Messing and Inworth Action Group

A12 Chelmsford to A120 Widening Scheme

Application for Development Consent Consultation on proposed changes to the draft Development Consent Order Application.

Reference; TR010060/Change Application Letter

Map Book 5: B1023 Roundabout

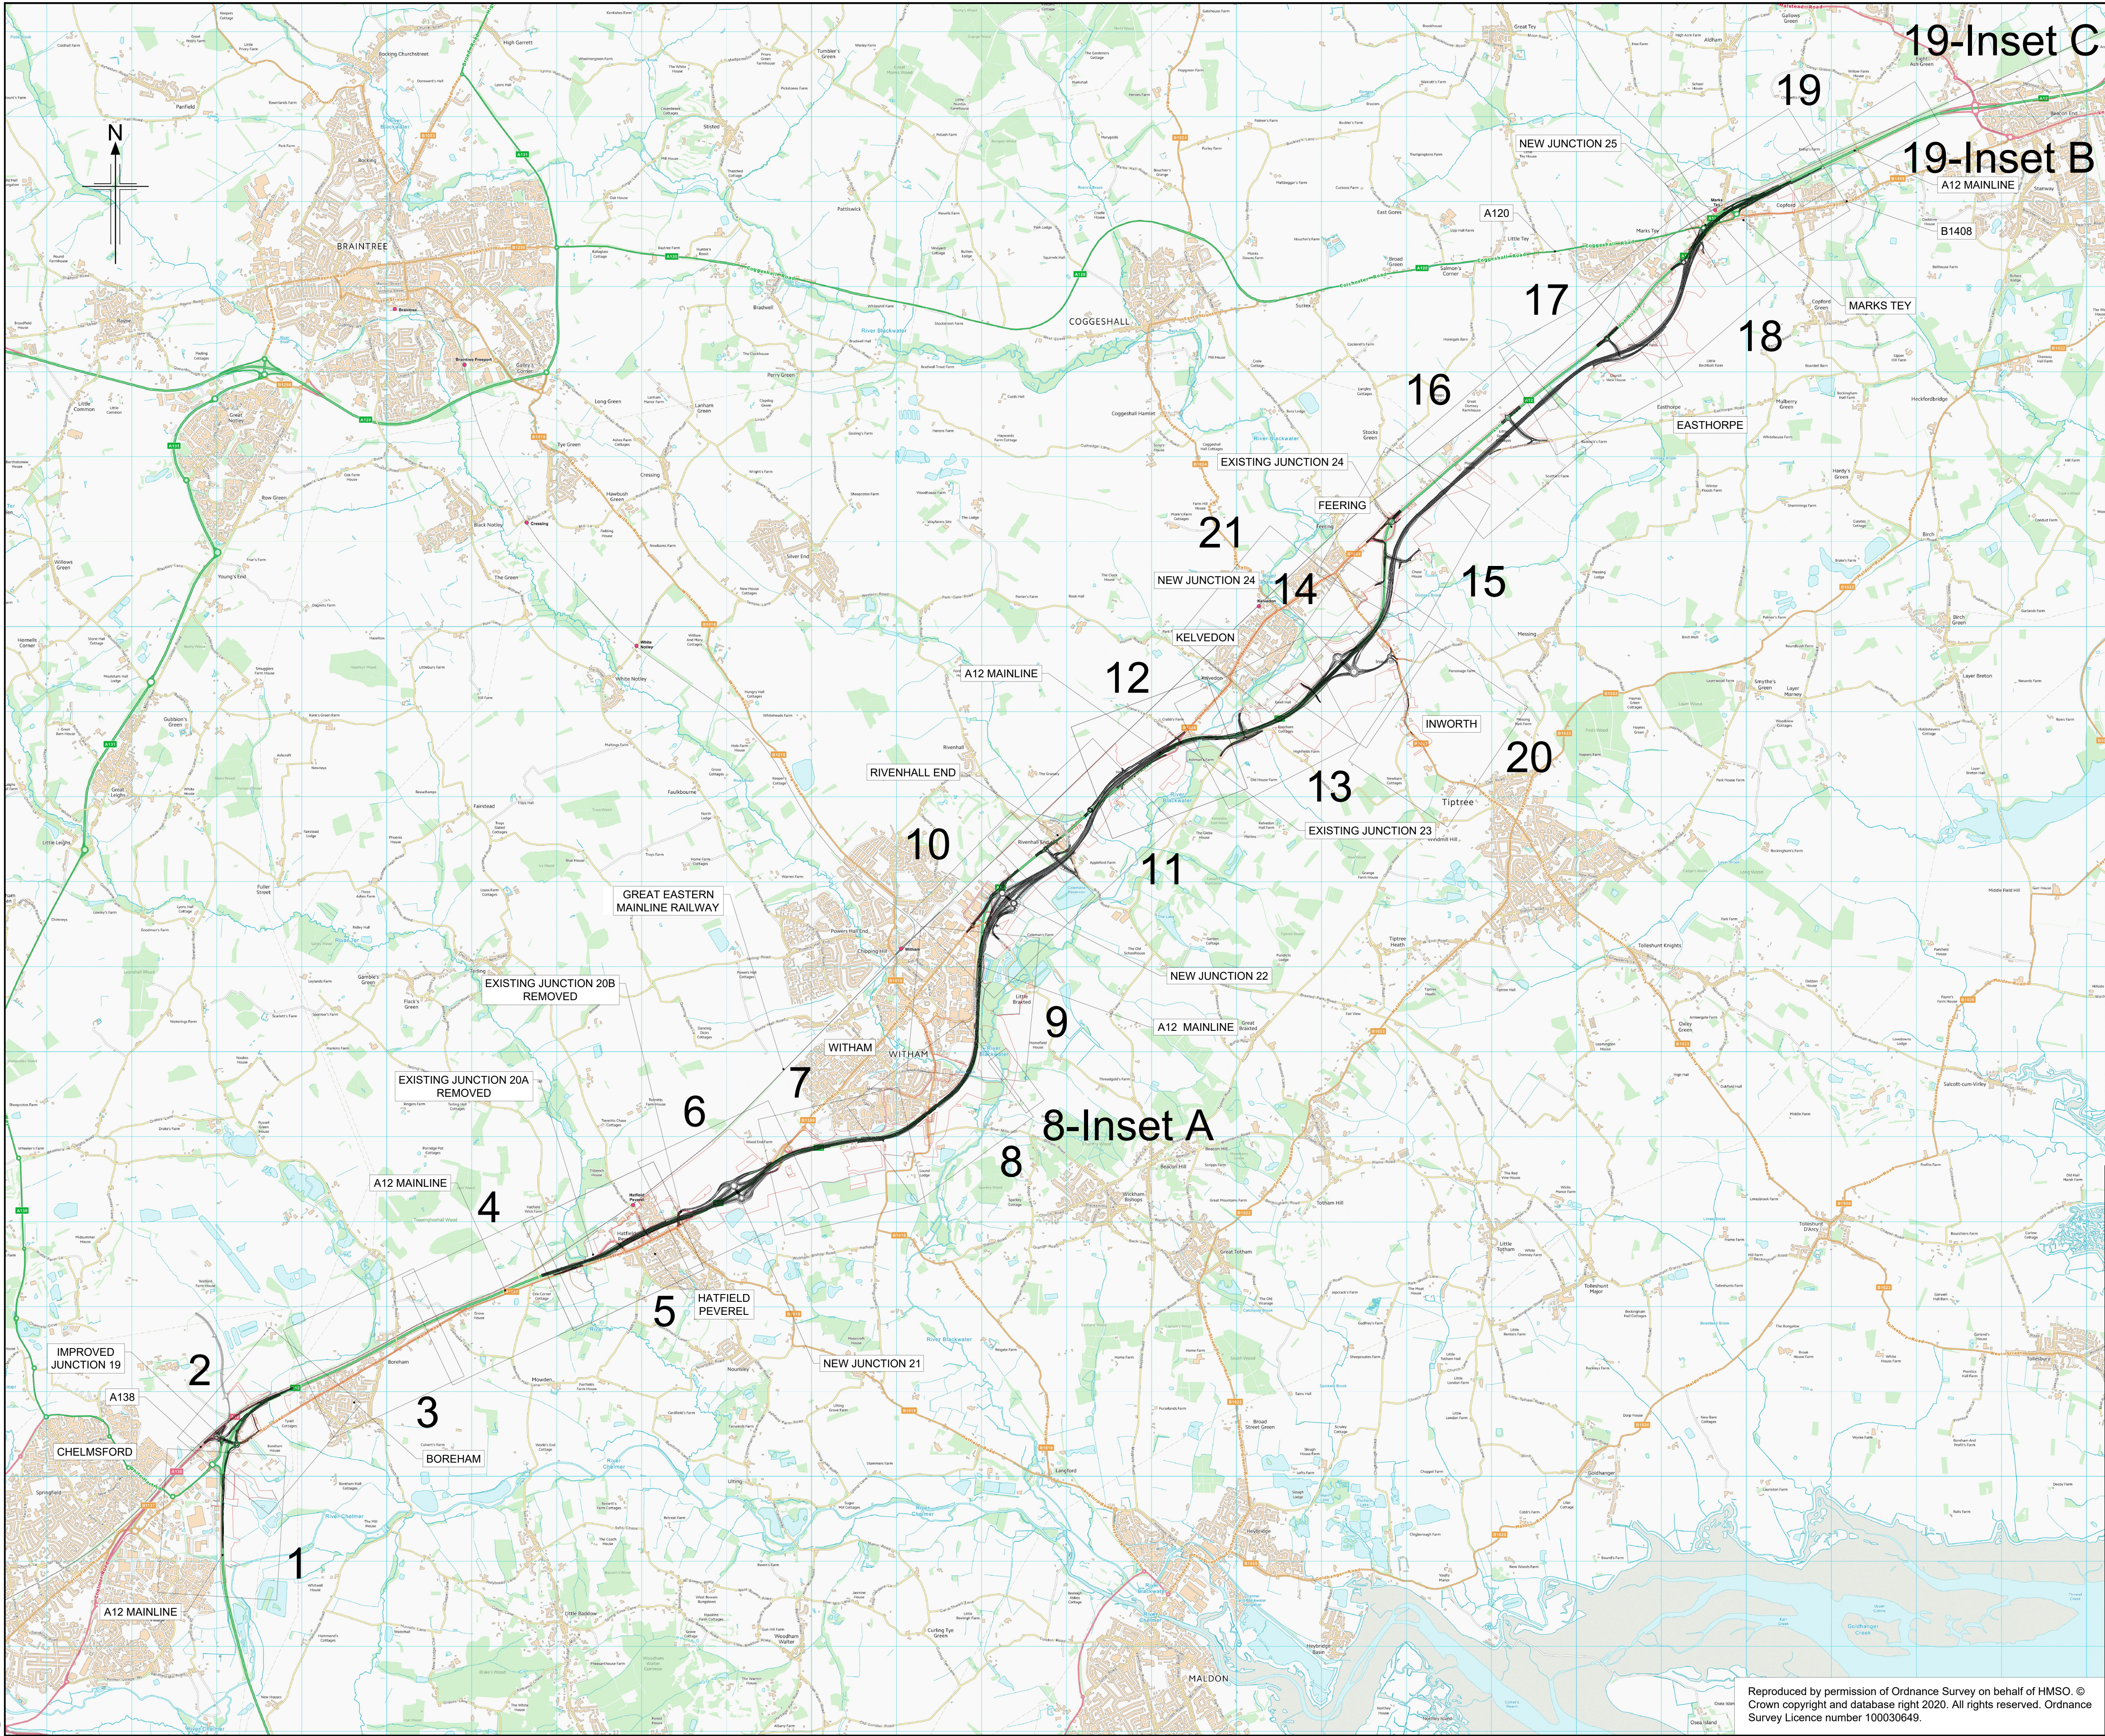
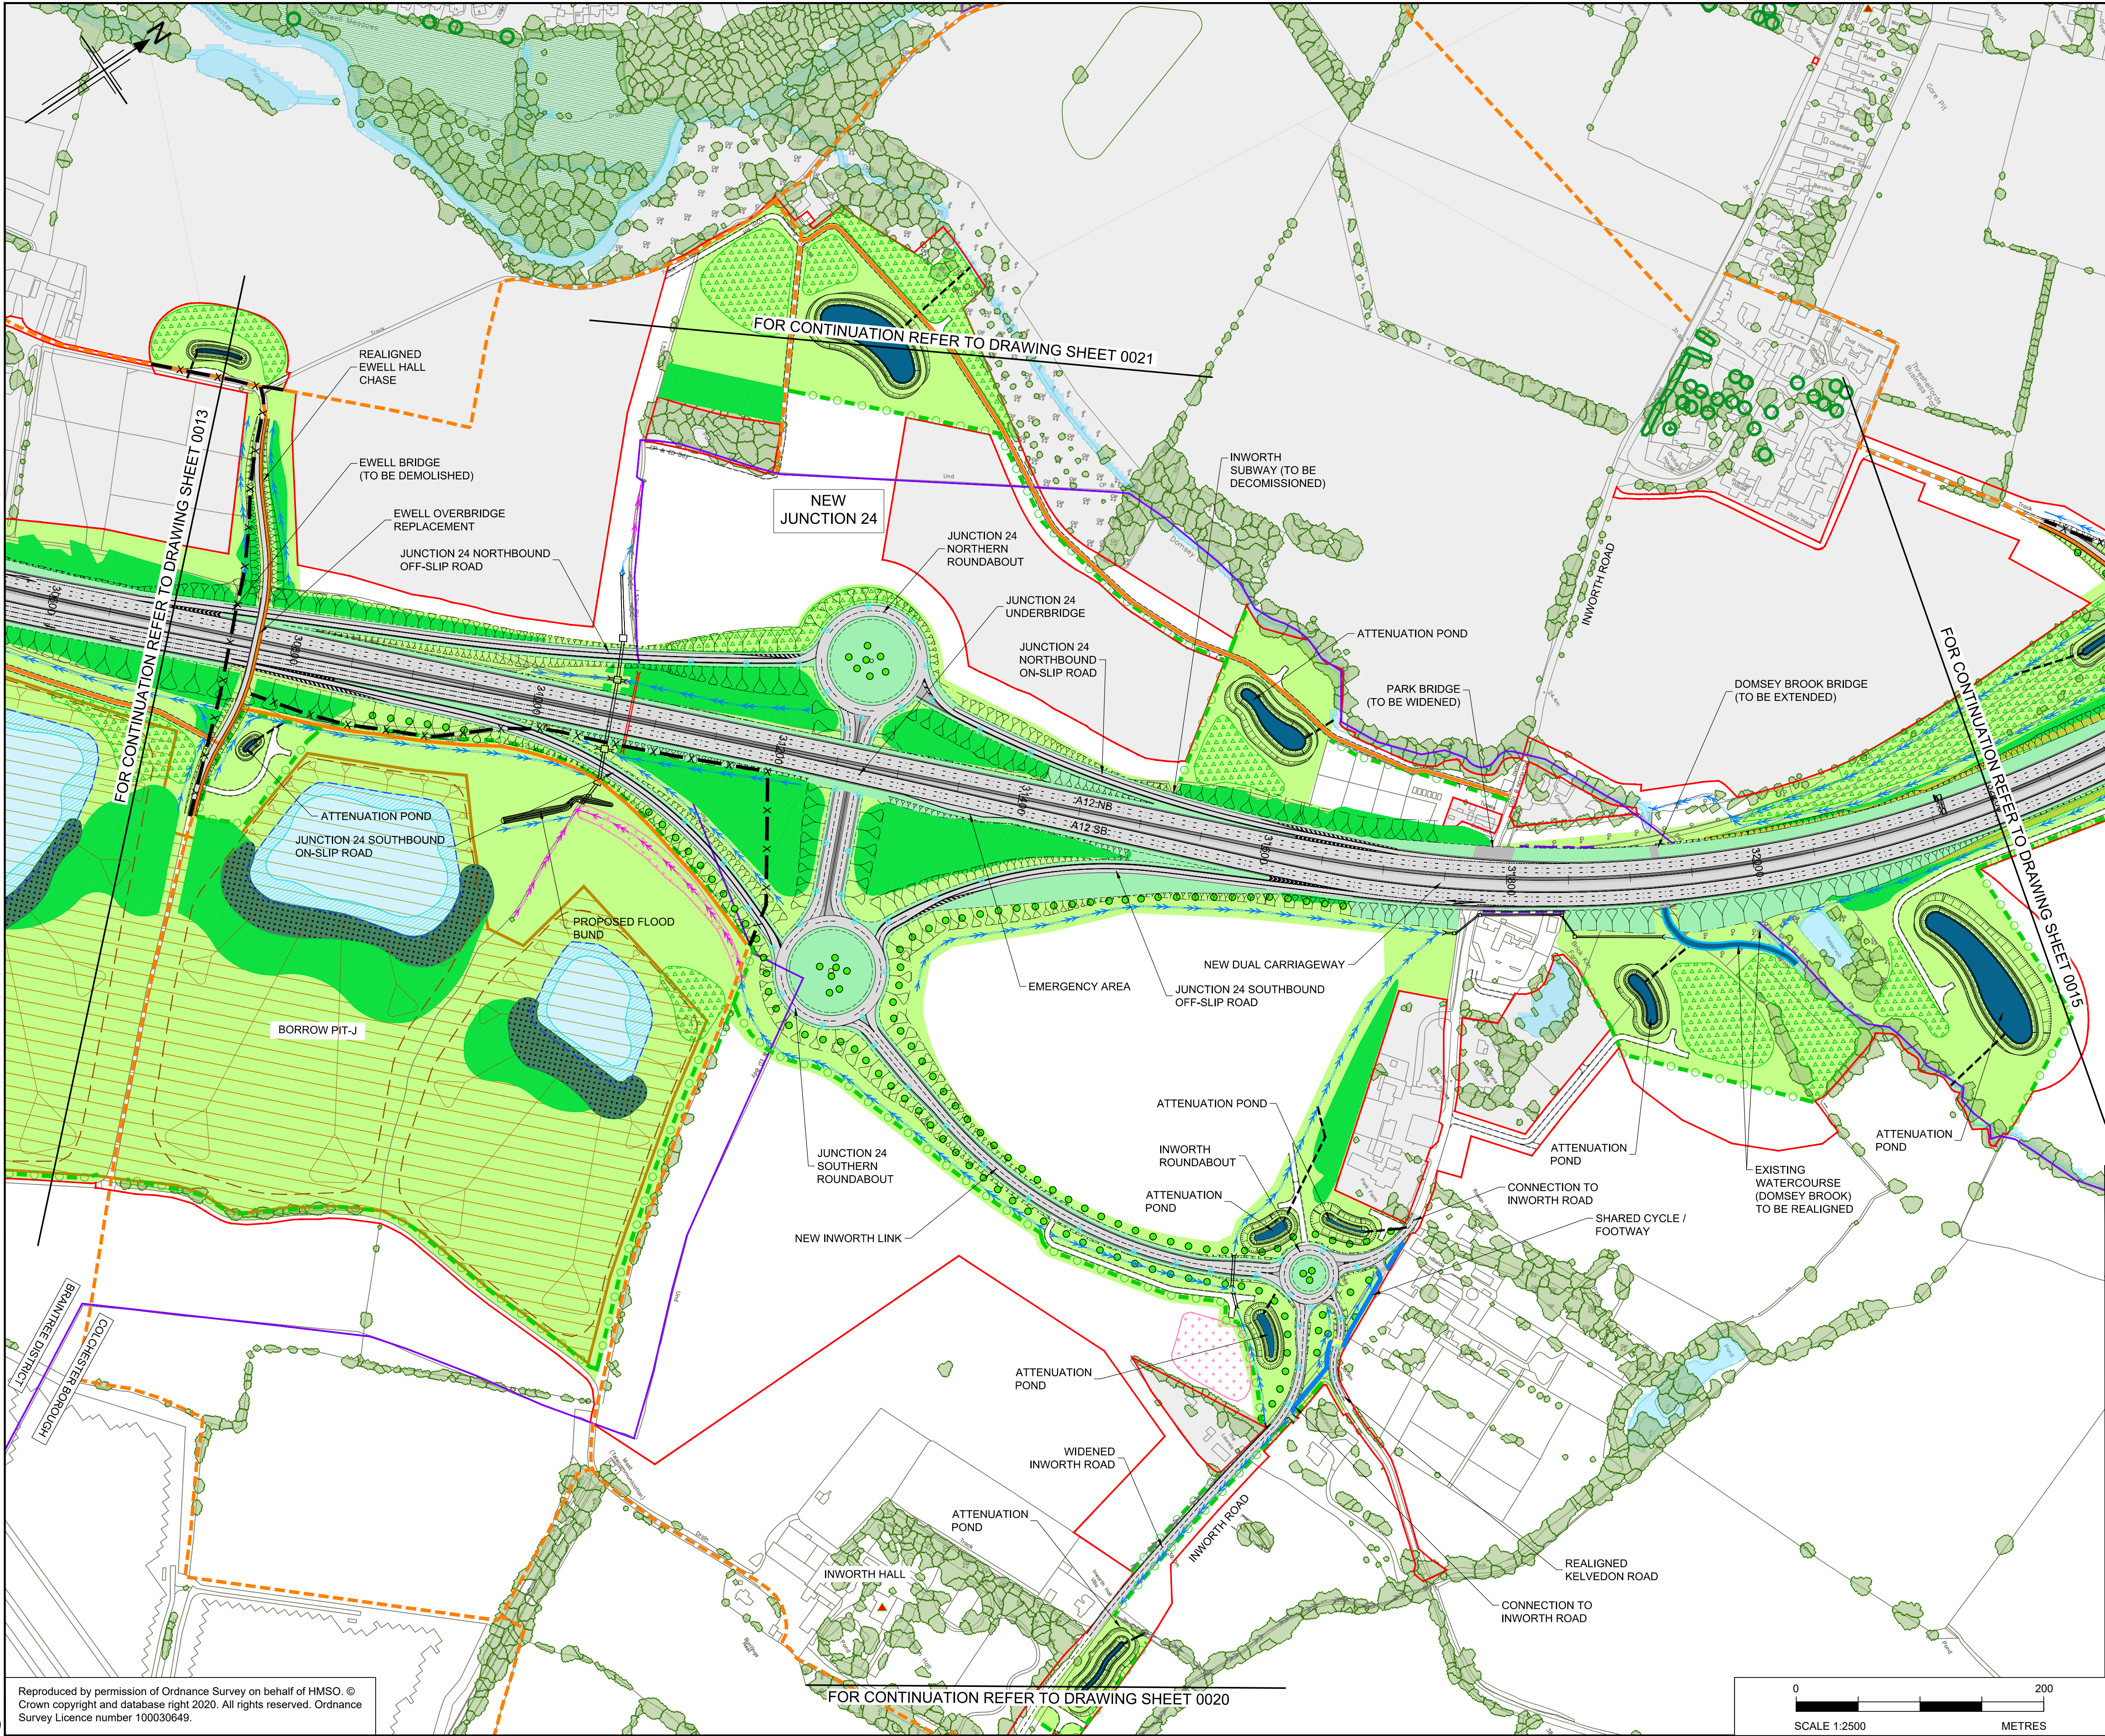
There is also a variation in the geometry of the Inworth Road north approach arm. The centreline horizontal radius of 67.5 m has been increased to 75.0 m compared to the design submitted in the DCO application.

Where is the notification of this change made apparent?

Visibility; the Applicant has previously stated that Inworth Road Roundabout arms (except the new link to Junction 24), have been designed to Manual for Street Standards (MfSS), with regard to horizontal radii and stopping sight distance (SSD). The reason given for this is in order to give road users the impression that they are entering a village environment and will therefore drive more cautiously. MIAG are of the view that MfS standards are not appropriate for roundabout approach roads in this rural location where there are open fields, and with no built frontage that would give road users the impression of being in a village.

No such speed restraint measures appear to have been proposed in the Applicant design for Inworth Road Roundabout.

MIAG are concerned about the low values of SSD on the approach to and exit from the roundabout. The arm connecting to Inworth Road north of the roundabout is of particular concern and MIAG do not feel confident that even the value of 43m SSD has been achieved for this arm. In fact, the proposed back of verge and earthworks appear to encroach into the Park Farm boundary.

Inadequate SSD checks carried out by the Applicant only continue as far as the tie in of the new works with the existing Inworth Road. This does not show the full effect of the new works on SSD.

If SSD checks are continued further along Inworth Road a 43m SSD line would be obscured by the existing brick wall on the boundary of Park Farm. Over this length, visibility values at 5m intervals were measured, the results were as follows: 40.5m, 37.2m, 34.2m, 32.3m, 33.2m.

This would indicate a length of about 30m of the alignment where the claimed 43m SSD is not achieved.

What makes this even more worrying for MIAG is that there is an entrance to Park Farm immediately following this reduction in available visibility. This would make access and egress extremely hazardous for residents of Park Farm when vehicles approaching after leaving the roundabout will have very little forward visibility.

Exit visibility for Kelvedon Road, the eastern arm of the roundabout, does not seem to have been considered at all. In this case, values of SSD would fall to as low as 26m, with the 43m long visibility line crossing the DCO boundary into the adjacent property.

Oddly for approach roads that are supposedly designed to MfS standards for visibility, the Applicant have shown what at first sight appear to be DMRB standard forward visibility lines on the approach to the give way lines. Forward visibility lines of approximately 70m length (suitable for a 50kph design speed), have been shown for the Inworth Road arms to the north and south of the roundabout and for the Kelvedon Road approach.

This degree of visibility would not be compliant with DMRB standards.

Even this length of forward visibility would not be available from 1.5 x SSD distance in advance of the give way lines for these arms, as required by CD 109 paragraph 2.13 (6) (DMRB).

This series of maps makes no attempt to be anything other than justification for the determination to drop the SLTL. This has been advocated by MIAG in the face of considerable opposition from the Applicant. MIAG now considers that all statistics and information used by the Applicant are called into question as this fundamental design flaw and perilous safety hazard was ignored for at least 14 months by the Applicant.
